From: June Grinstead [REDACTED]
Sent: 13 November 2018 09:33
To: Zac Denton
Subject: Re: 67 Norfolk Road
Attachments: 105.pdf

Block Plan

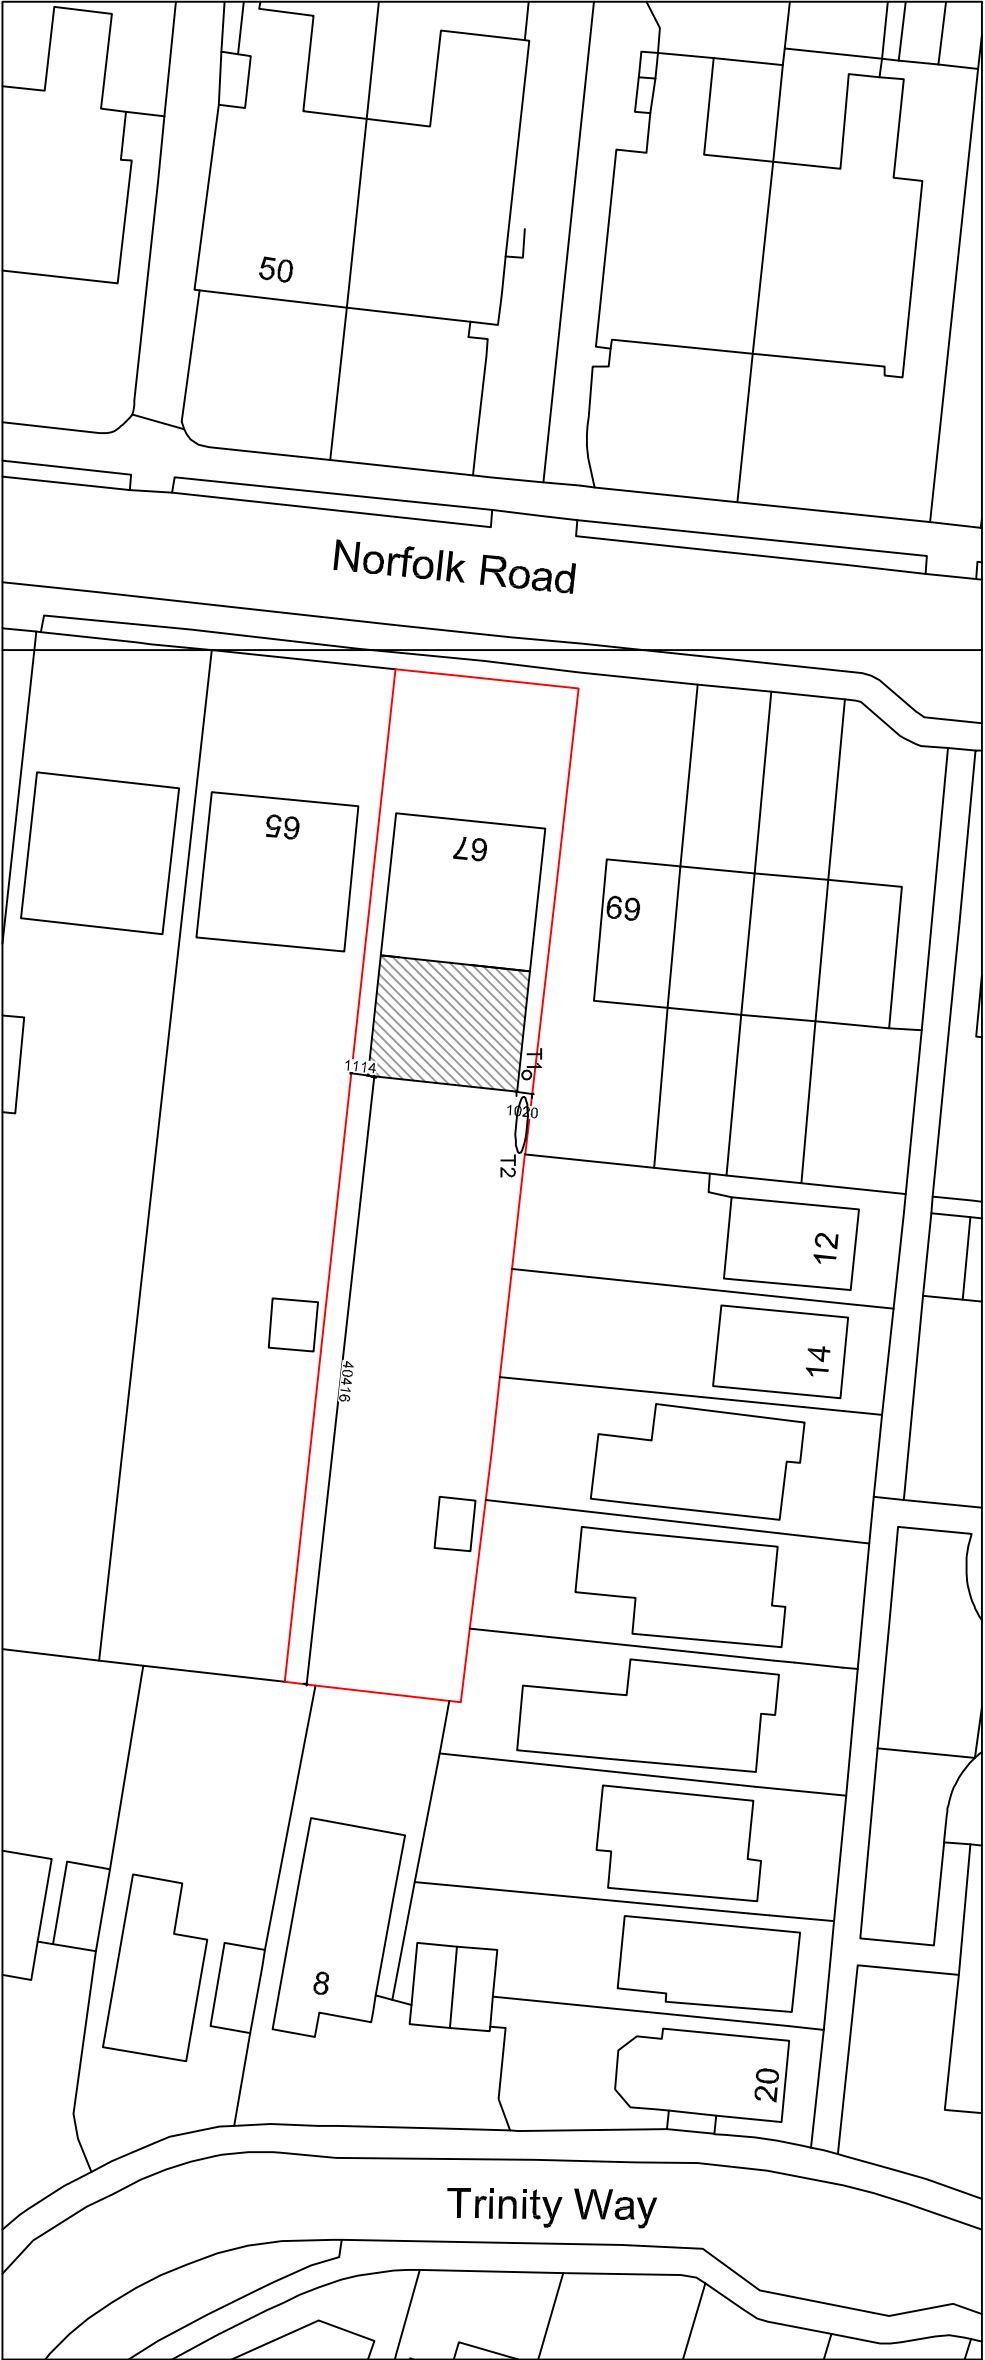
The applicant has confirmed that she is going to plant bamboo along the fence to replace the Holly Tree and Shed, which grows higher than the fence. Would you like me to add this to the block plan?

I very much appreciated your call this morning. Please find attached the revised Block Plan as requested. If there is anything else I can do please let me know.

Landscape Plan
1 : 100

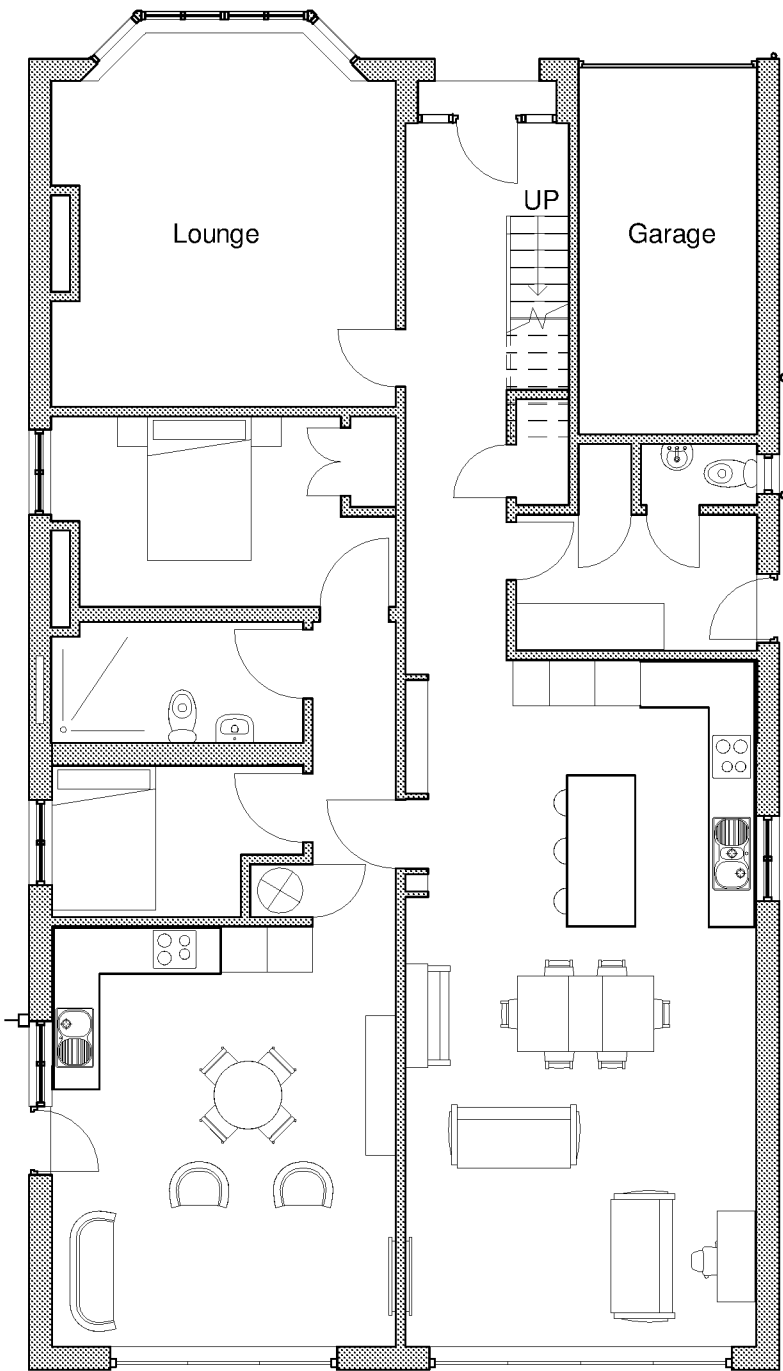
Information relating to planting/removal of foliage could be submitted on a landscaping plan. This could then be submitted to support the proposal.

Please find attached another drawing sheet, this shows the fence along the boundary and the location of the new planting.
